File Name	Prepared	Reviewed	Issued by	Date	Issued to
P4606.001T Saints Peter and Paul Assyrian Primary School	S. Daizli	A. Giyahi	A. Giyahi	10/06/2020	David.Way@planning.nsw.gov.au
Cecil Park TIA Peer Review		-

## Saints Peter and Paul Assyrian Primary School, Cecil Park

## **Traffic Impact Assessment Peer Review**

DRIVEWAY AND KISS & DROP ZONE

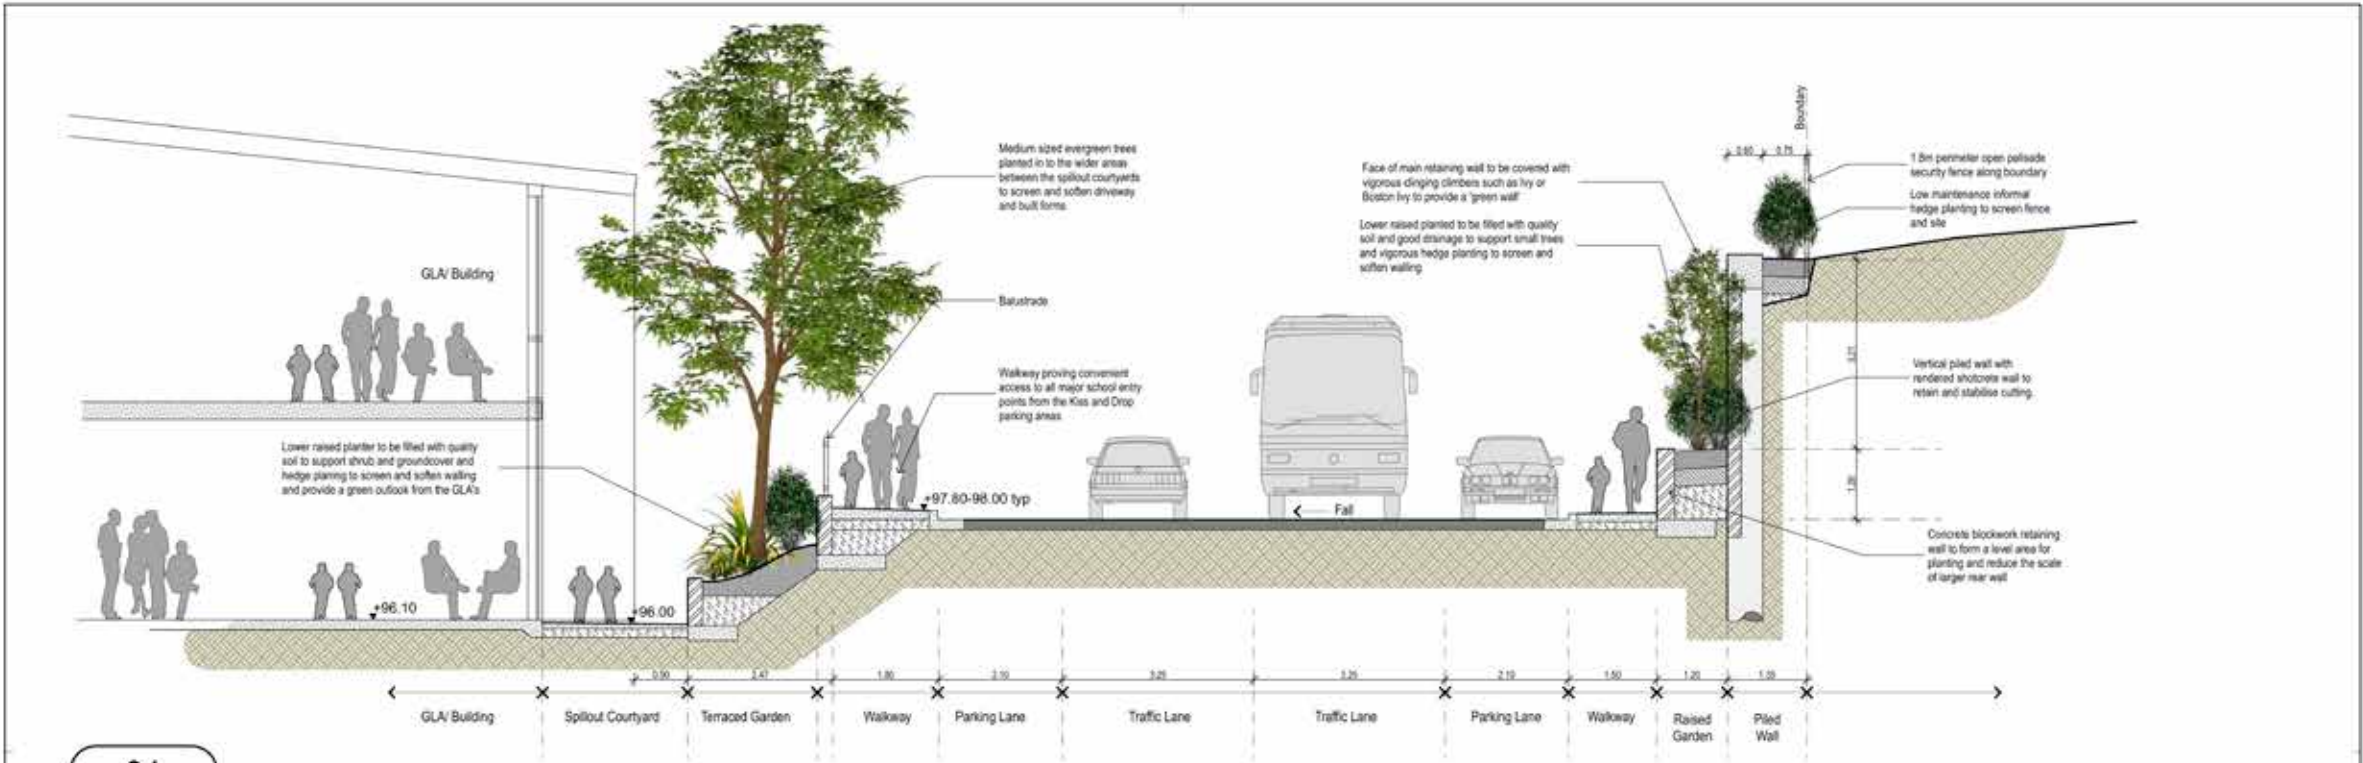
The staff parking spaces will conflict with parents/carers using the pick-up/drop-off spaces and as such, a separate staff parking area should be provided.

Pick-up/drop-off spaces 3, 4, 16 and 17 should not encroach the adjacent crossing to maintain drivers' sightlines to pedestrians and vice-versa. If these spaces cannot be relocated/resized, then these will need to be removed. Additionally, there should be 20-metre and 10-metre No Stopping zones before and after the crossing respectively in both directions of travel.

The proposed location of the southern crossing is adjacent to the "Keep Clear" area where multiple, conflicting vehicle movements will be made and drivers leaving the queueing area and U-turning will have little sight distance. One of the following alternatives should be considered:

- 1. Relocate the southern crossing further north along the driveway and comply with the above No Stopping zone requirements. Adjacent pick-up/drop-off spaces will need to be removed if they cannot be relocated/resized. An additional staff member ("7") will be required to fulfil the same role as Staff Member "2" at the relocated southern crossing. They will need to work with Staff Member "3" to ensure efficient traffic operations
- 2. As per Option 1, but also ban the U-turn arrangement. This will require drivers leaving pick-up/drop-off spaces 15 to 28 to exit the school either via the circulating loop or a bypass lane
- 3. Remove the northern and southern crossings and provide one crossing in the middle of the driveway. This would be managed by Staff Member "2".

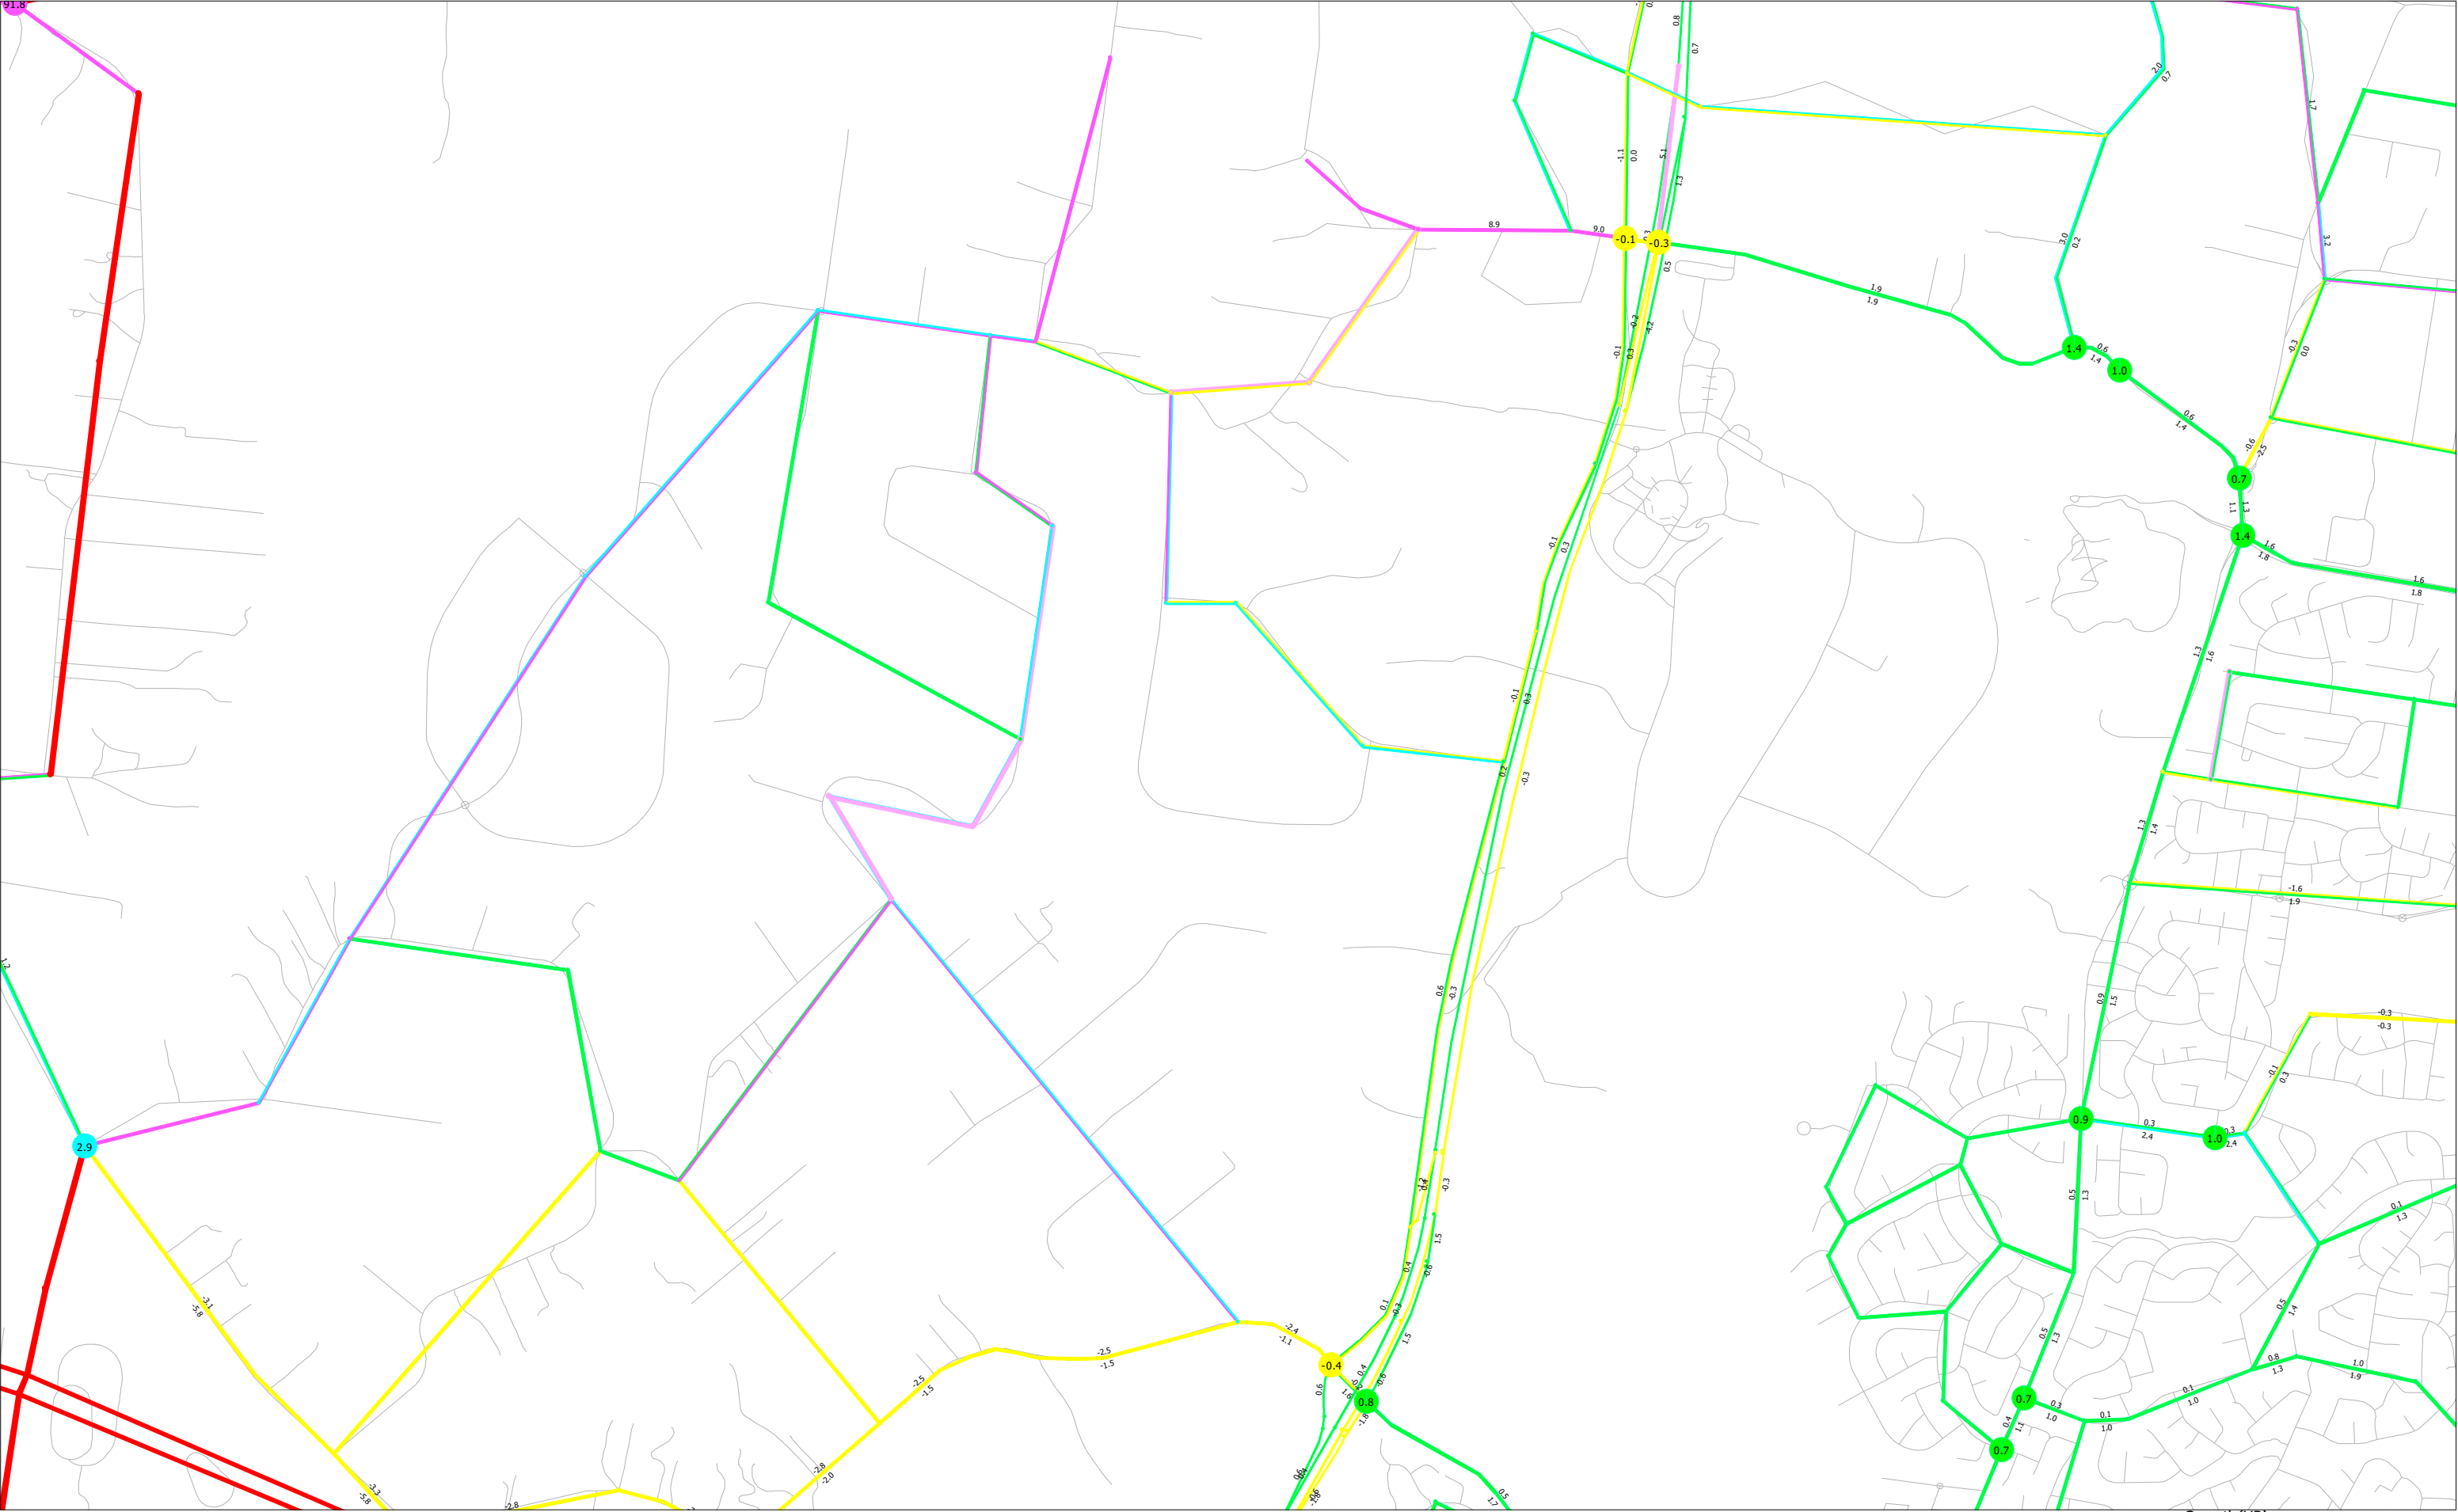
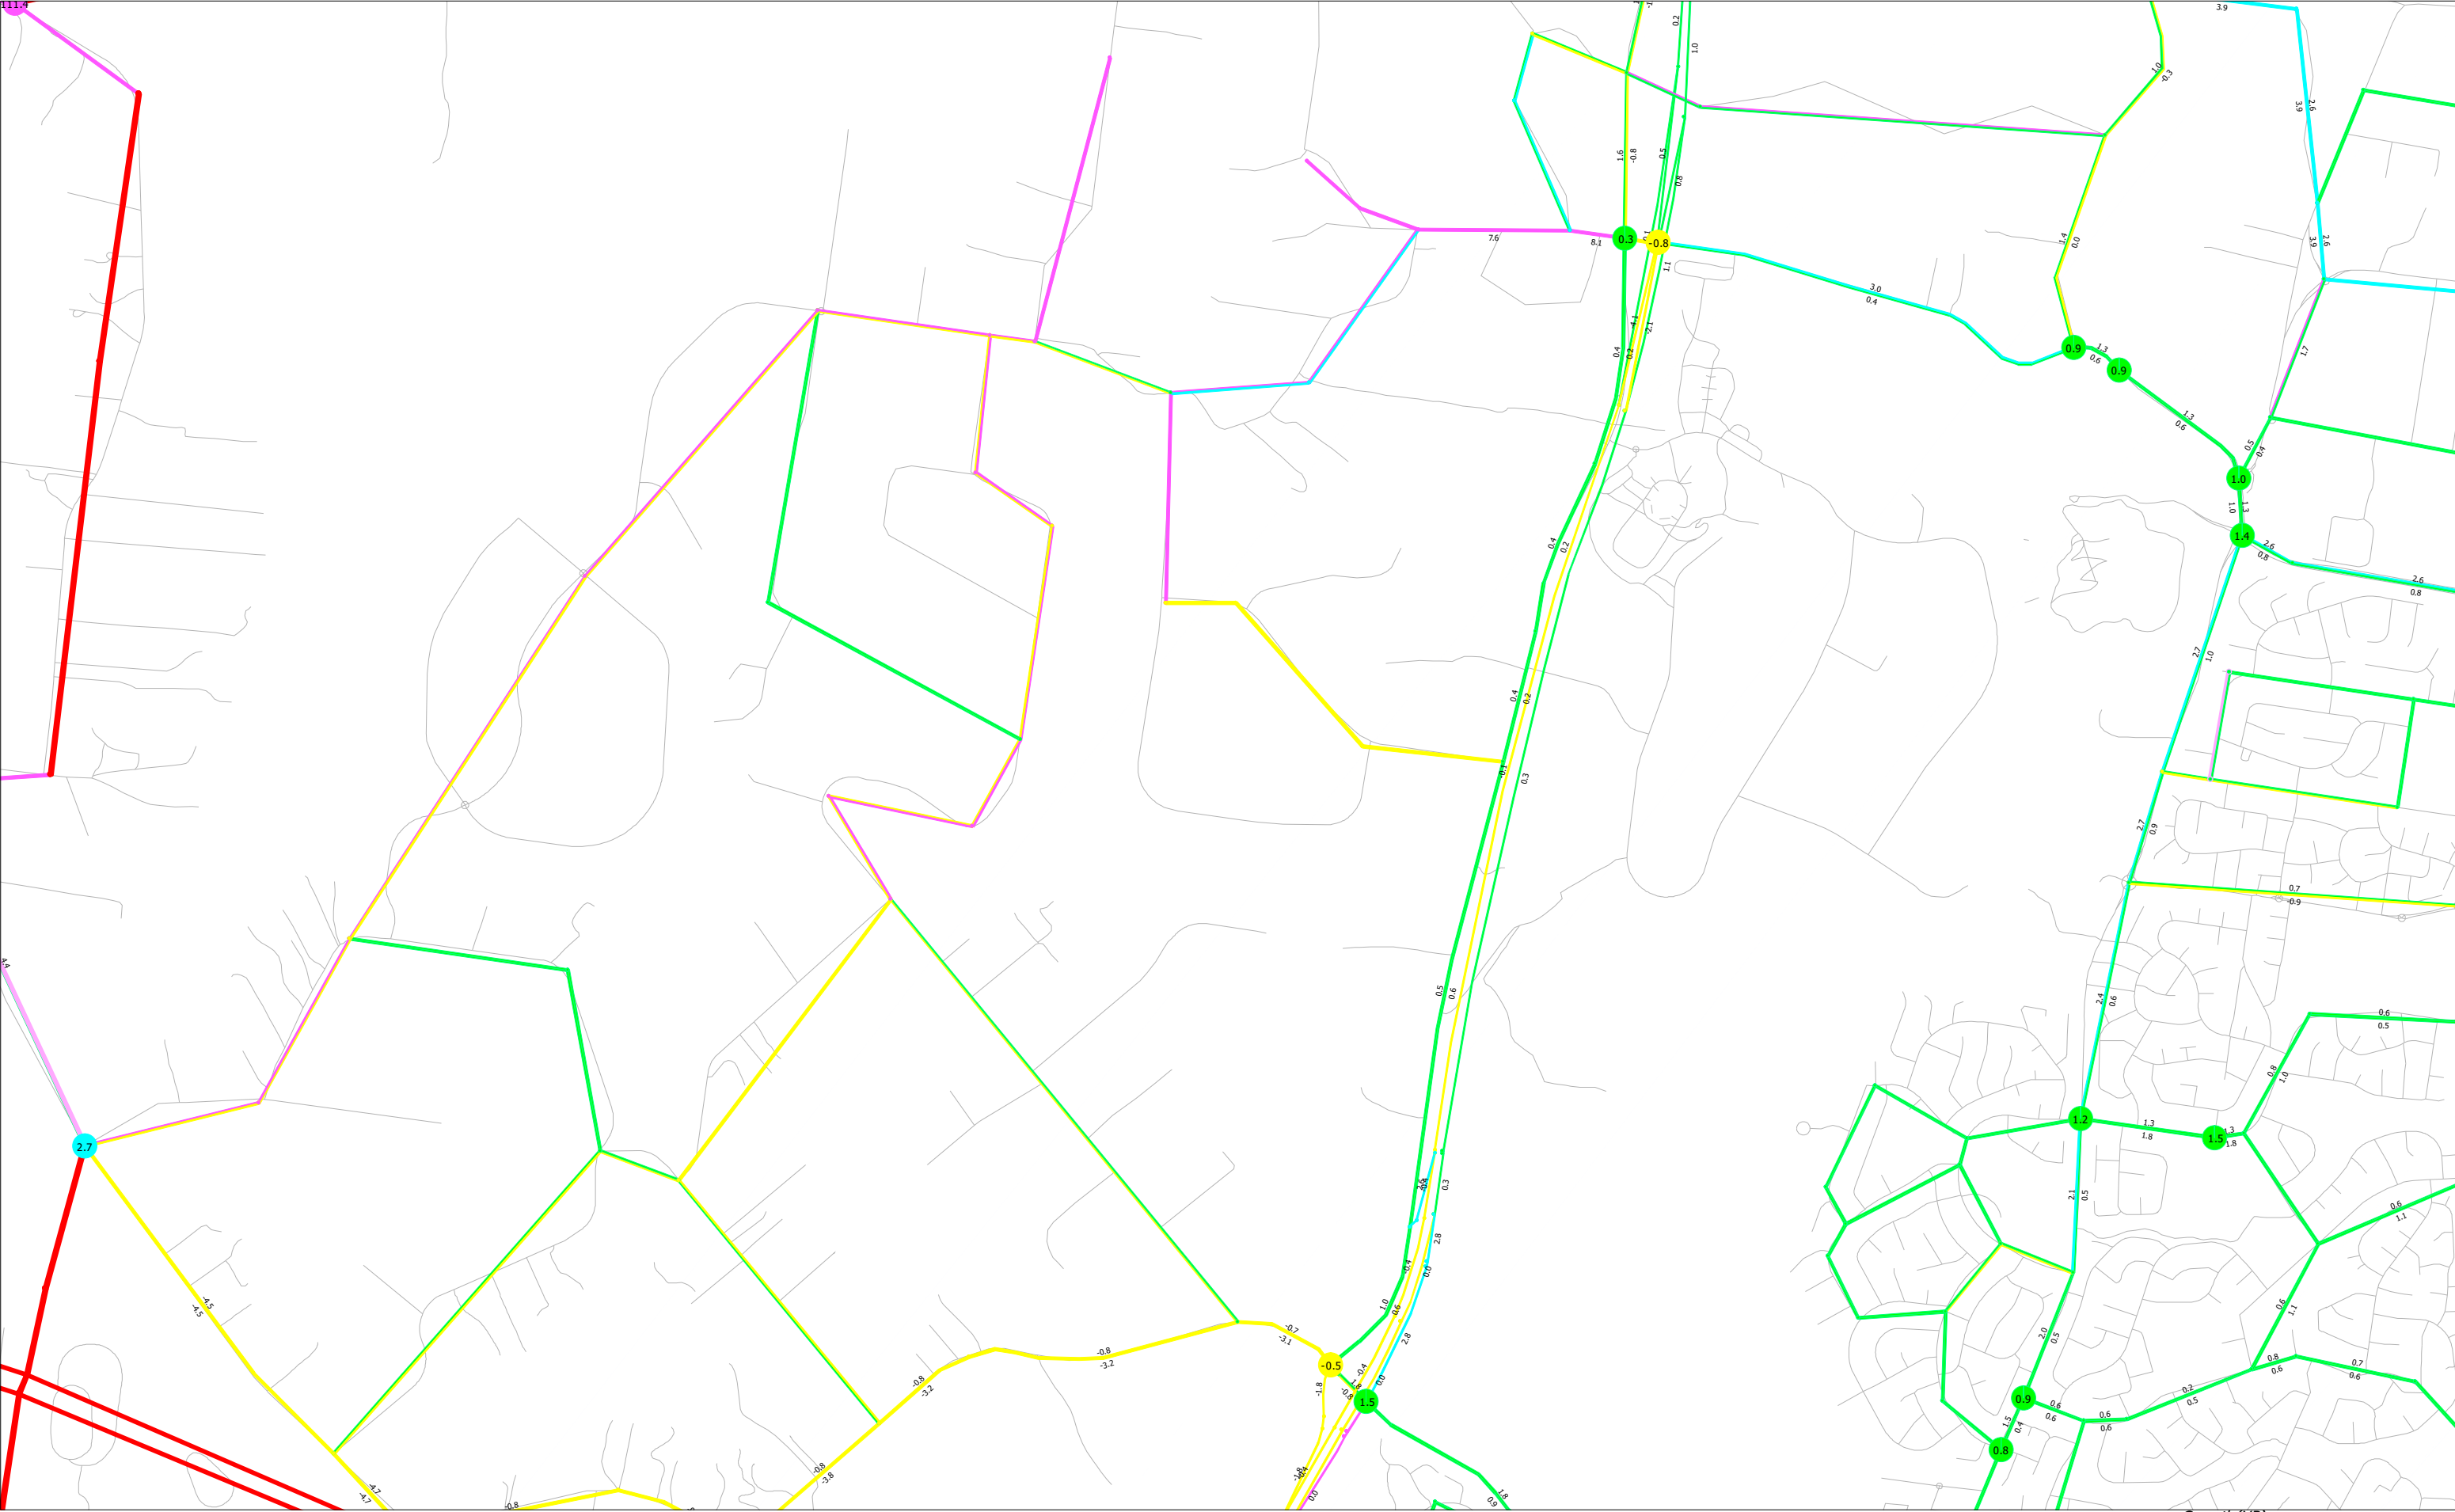
If negative growth rates were applied to calculate the 2028 turning volumes, then the 2018 volumes should be retained to avoid misinterpretation and maintain robust volumes. Technical rationale would be required to justify negative growth rates. In the absence of any reasonable rational, Sydney Strategic forecast model should be used to assist with the forecast volumes in the surrounding road network for the future year.
